Environment Agency

WRITTEN REPRESENTATION

HIGHWAYS ENGLAND'S RESPONSE

1. *Following the Highways England submissions for Deadline 5 we have reviewed several documents with regards to our remit. We wish to note the following comments on the topics of flood risk, Highways England responses to the Examining Authority (ExA) second round of written questions and the draft DCO.*

| 514451-MUH-00-ZZ-DR-DR-400156 | 11 |

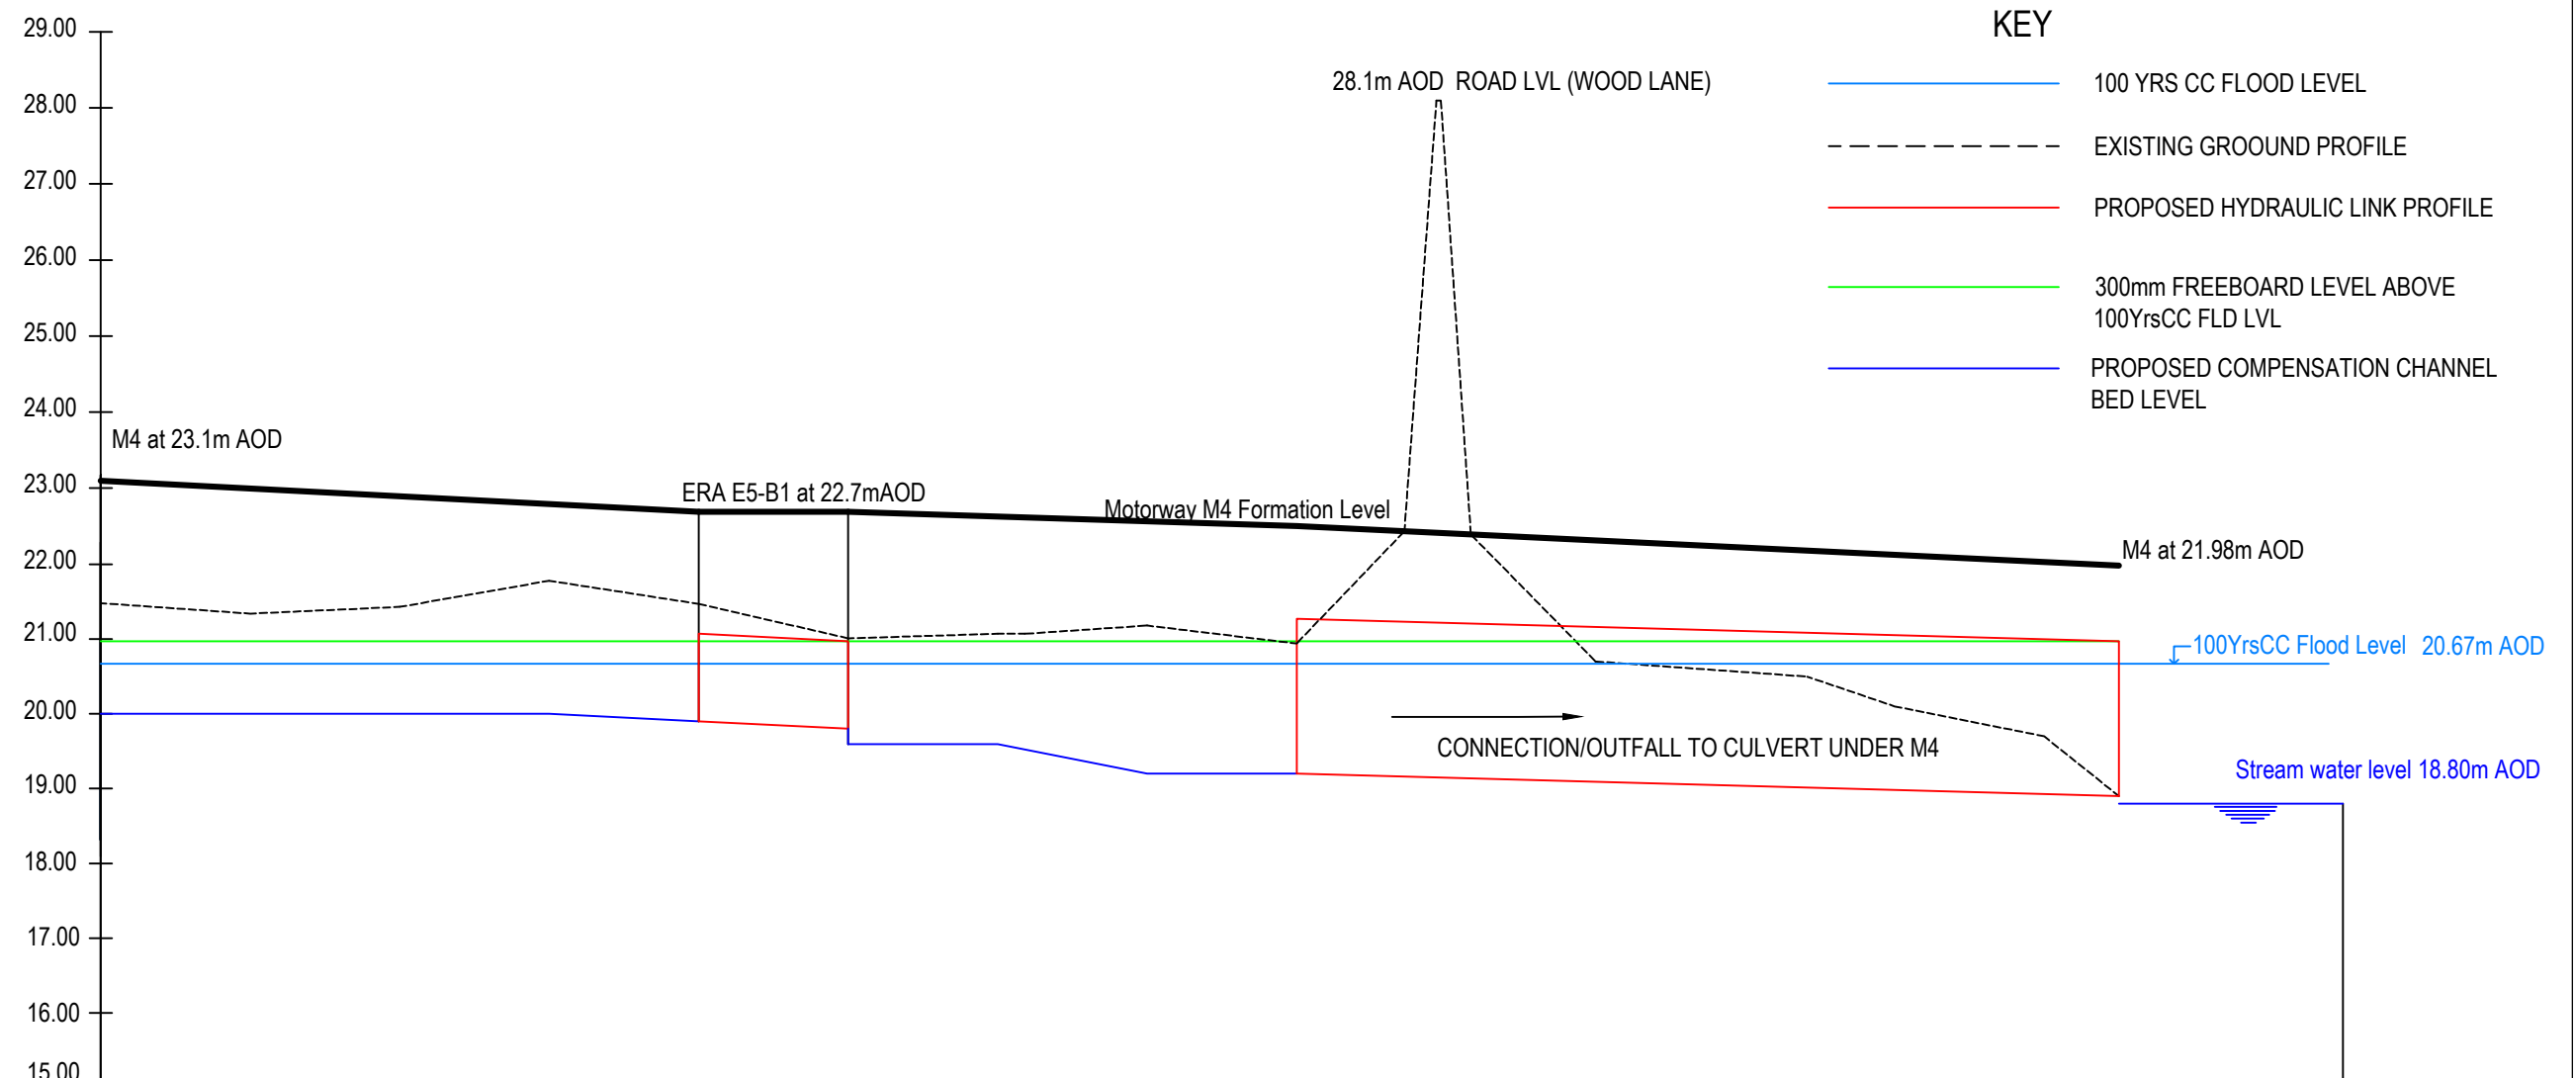
- 16.1 At the meeting on the 26 January, the flood risk mitigation measures proposed at Construction Compounds 5 and 7 were discussed and it was agreed that these measures will ensure a neutral flood risk impact associated with use of these compounds.
17. *In previous submissions we have raised concerns with regards to the hydraulic connectivity of the proposed FpC areas. The January 2016 FRA sets out hydraulic connectivity on maps provided in Appendix F, detailed in the calculations spreadsheet in Appendix D and an example long section drawing number: 514451-MUH-00_ZZ-DR-DR-400192 for the site*

reference R18/R19 has been submitted in Appendix E, showing how the hydraulic link will work.
